TERRA RIDGE NORTH Pre-Development Grading & Erosion Control Plan El Paso County, Colorado

Prepared By:
Lodestar Engineering, LLC
P.O. Box 88461
Colorado Springs, CO 80908
OCTOBER, 2022

EL PASO COUNTY PRE-DEVELOPMENT
 TERRA RIDGE NORTH
 INITIAL, INTERIM & FINAL
 SITE GRADING & EROSION
 CONTROL PLAN

EL PASO COUNTY PRE-DEVELOPMENT  
 TERRA RIDGE NORTH  
 GRADING & EROSION CONTROL  
 NOTES

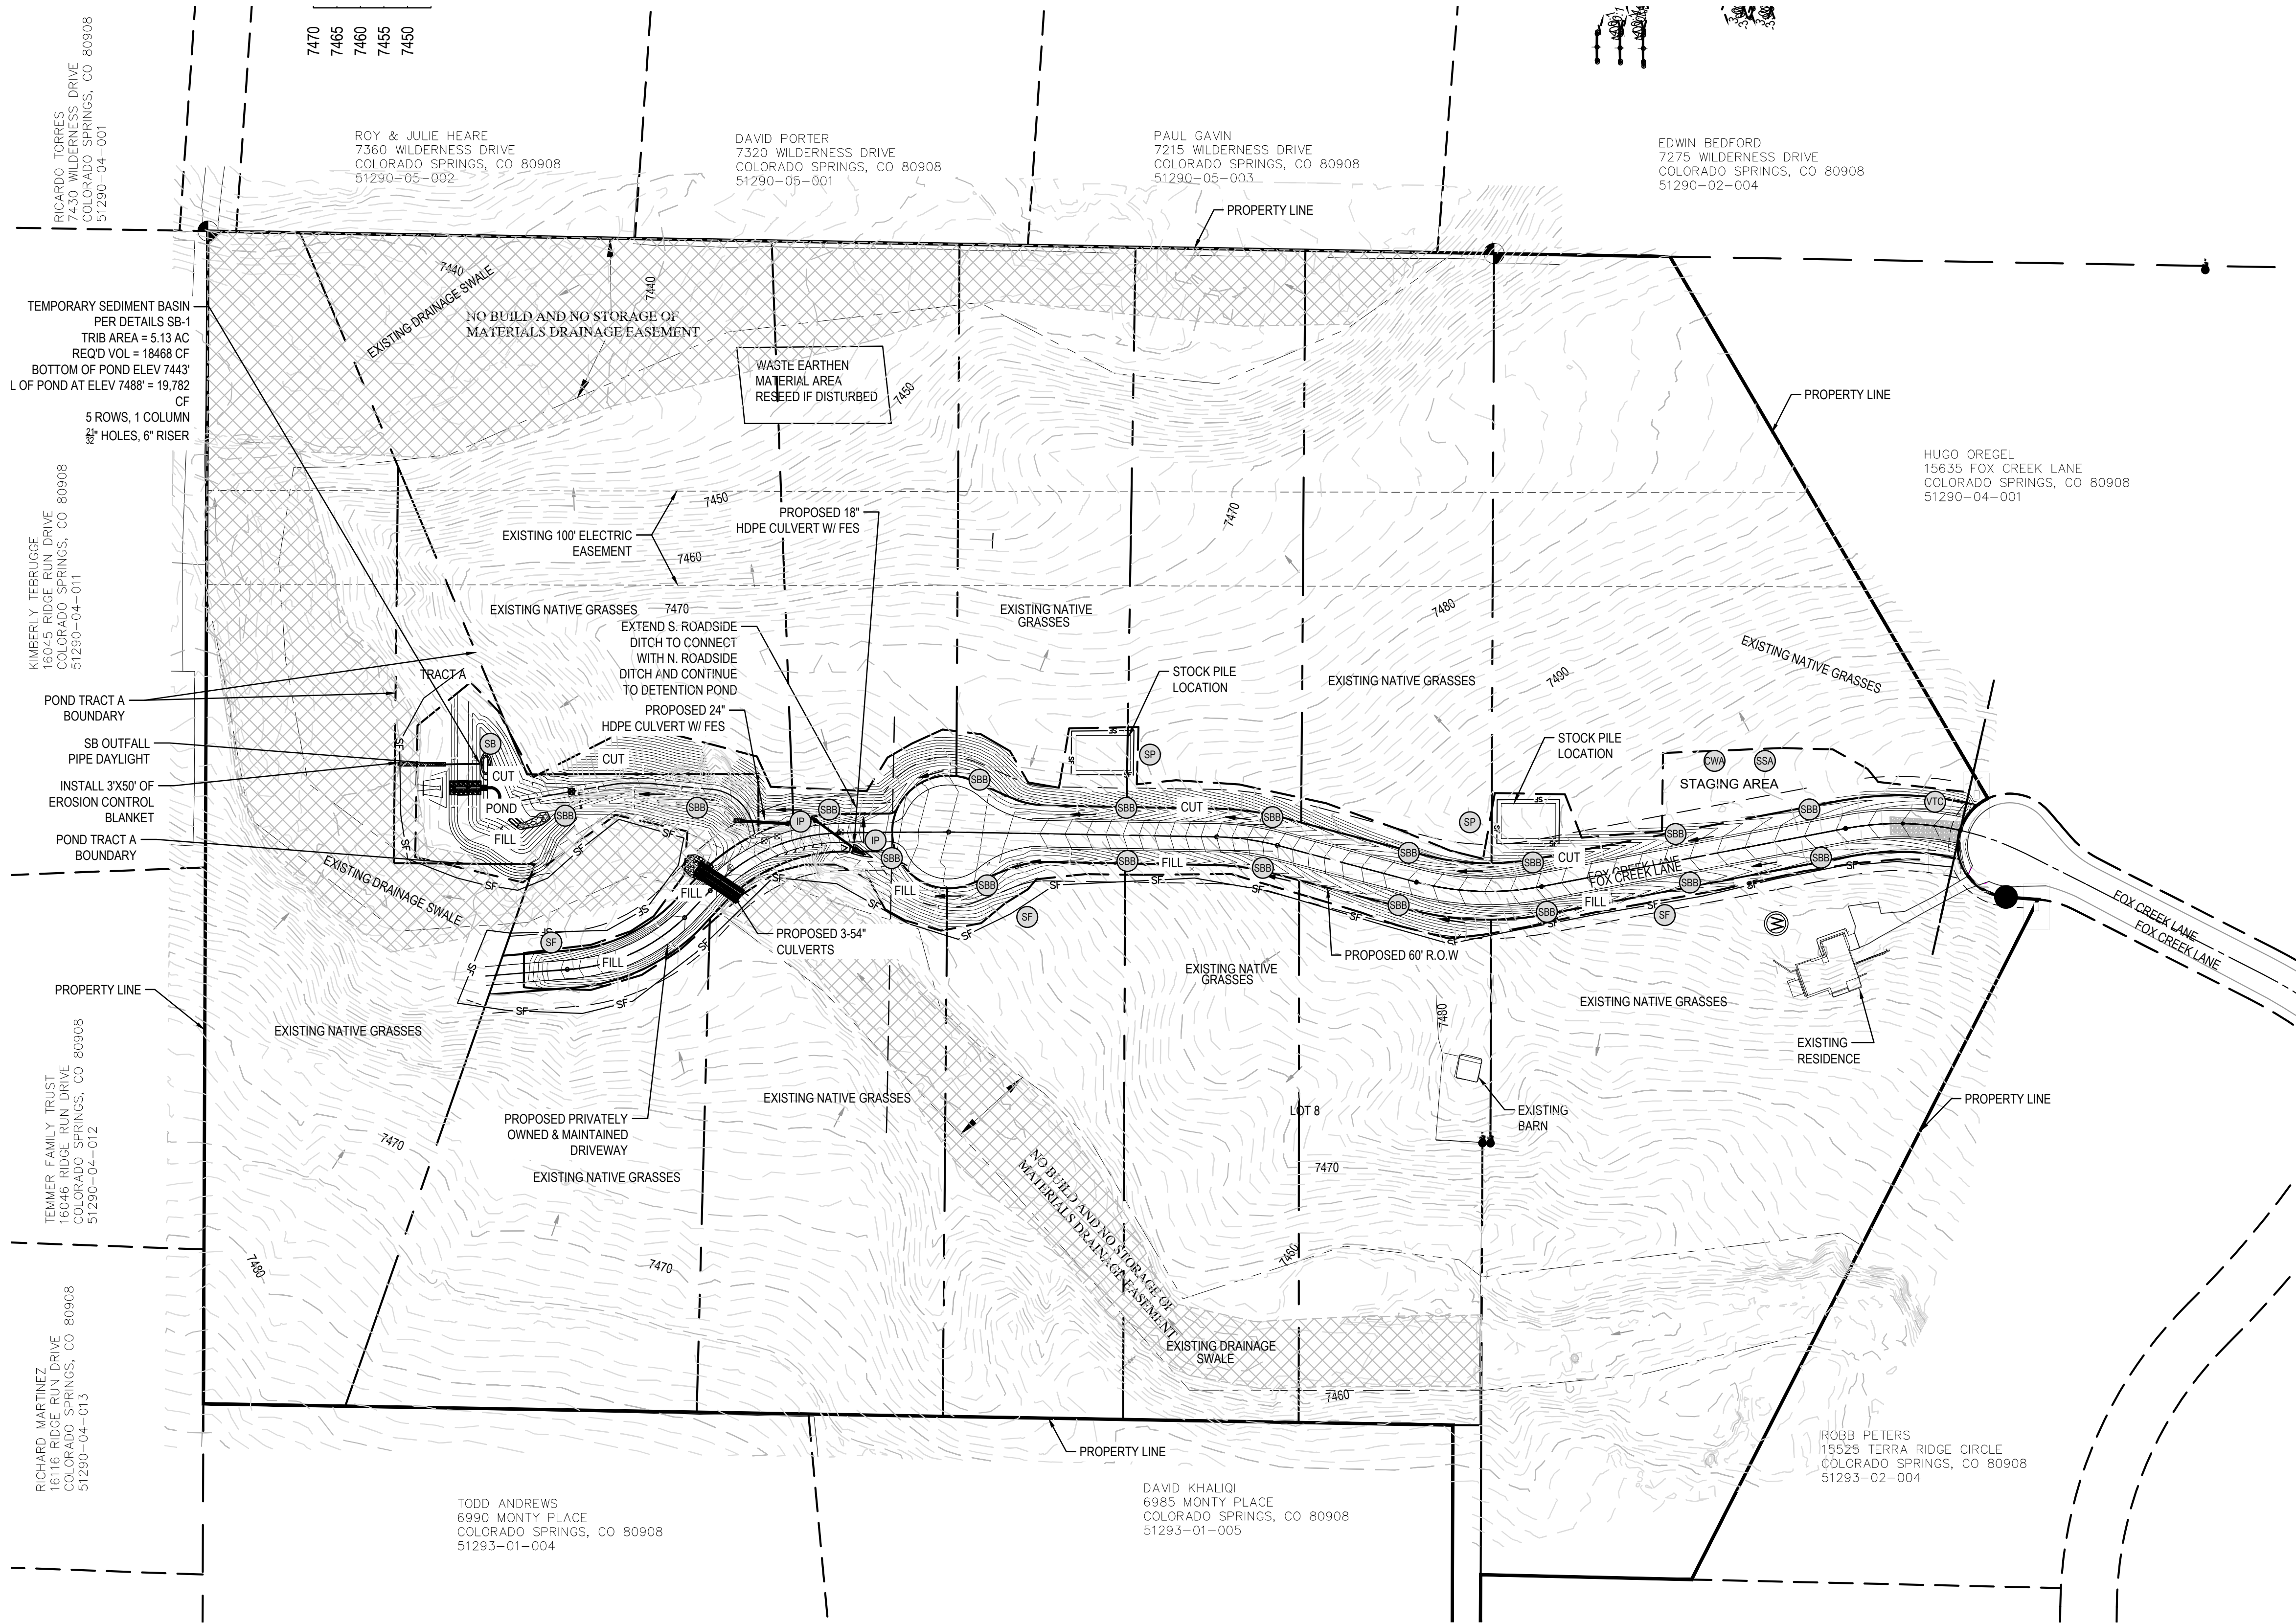
Which inlet is this IP supposed to be for? Is it supposed to be for the 2-48" culverts just to the south?

Show locations of seeding and mulching on plans and add to Legend.

For drainage report if ECB to utilized, show location on plans and add to Legend. And provide a detail on the next sheets.
